Our Ref: R/276/19/HH
Your Ref:

Town & Country Planning Act 1990 (as amended)
Town & Country Planning (Development Management Procedure) (England) Order 2015
Application for Planning Permission for Works or Extension to a Dwelling

Development Demolition of garage and conservatory and erection of a rear extension
Location 9 Milton Avenue Rustington

Project: Proposed extension; 9 Milton Avenue, Rustington BN16 2PP	
Drawing: Plans and elevations as proposed	
For: Mr. & Mrs. Lamb	
Drawn: PKS	Date: November 2019
Scales: 1:50 1:100	No: 2523/01/02
To scale when printed on A3

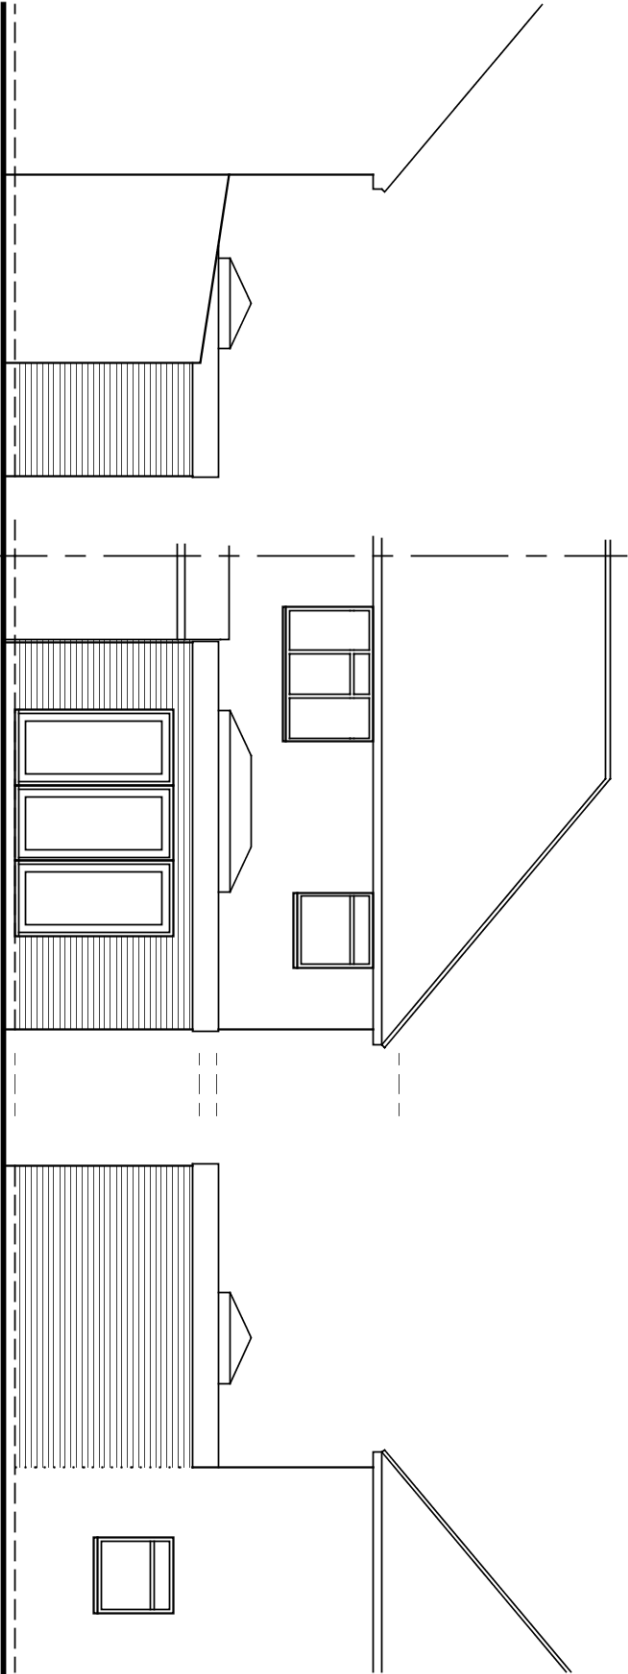
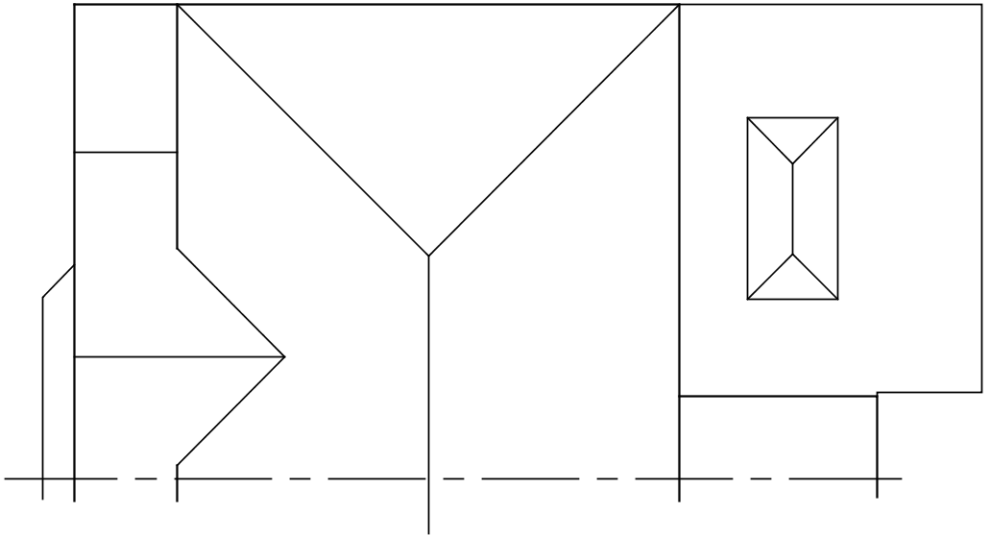
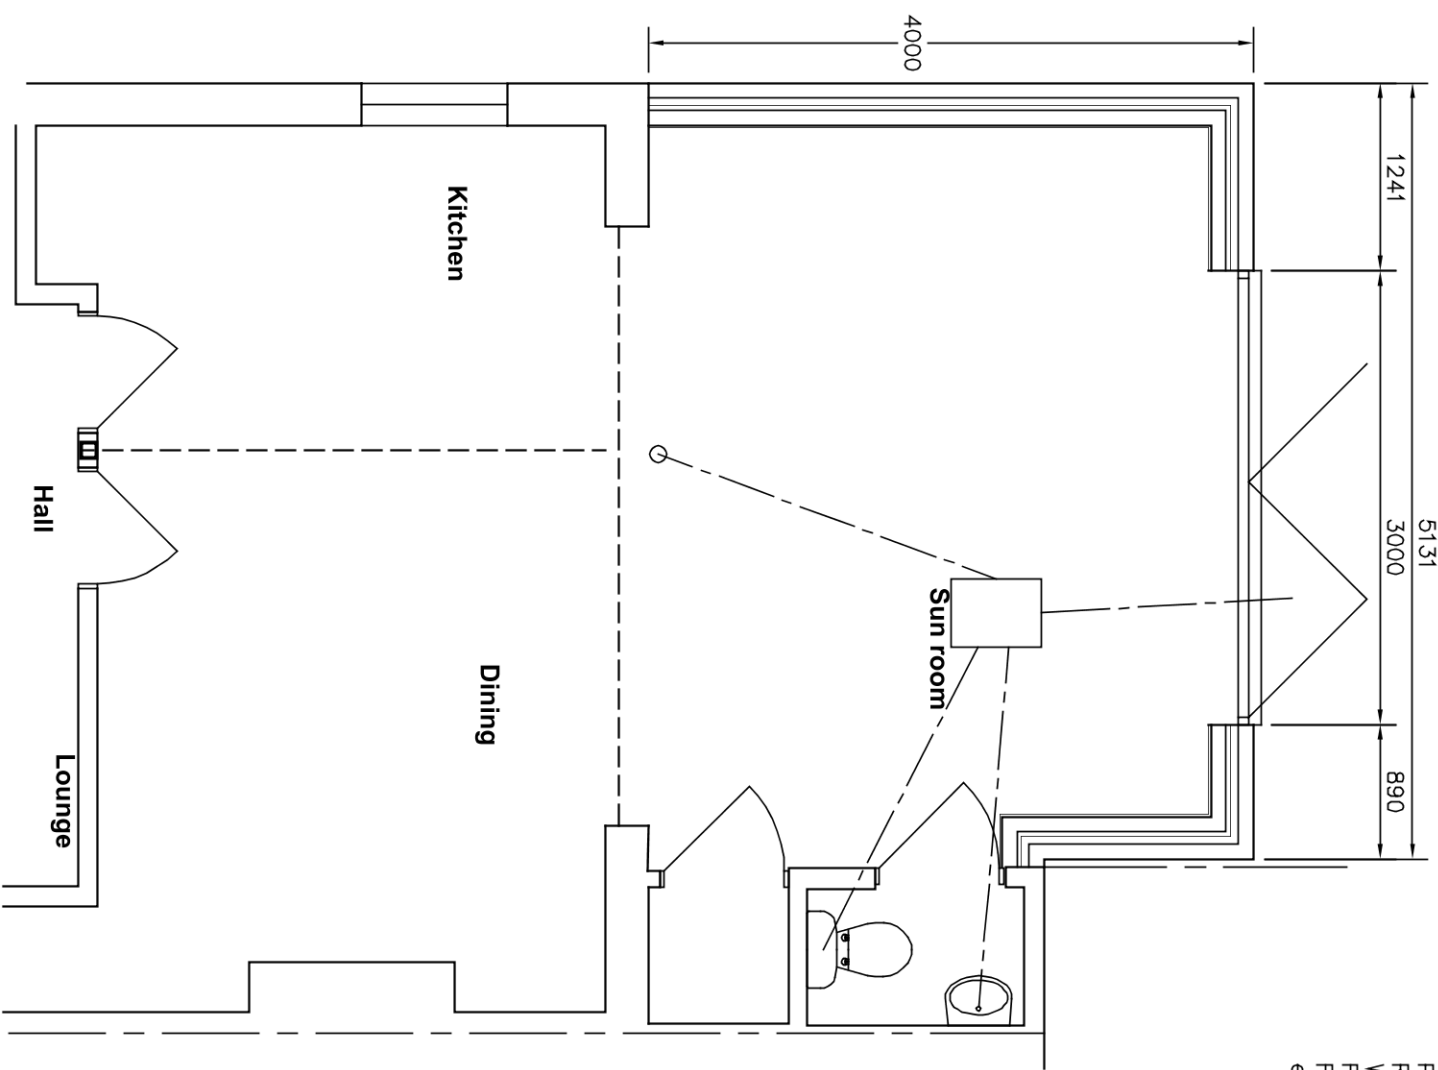
Building Line: The building line is inconsistent between the proposed ground floor and proposed side elevation.
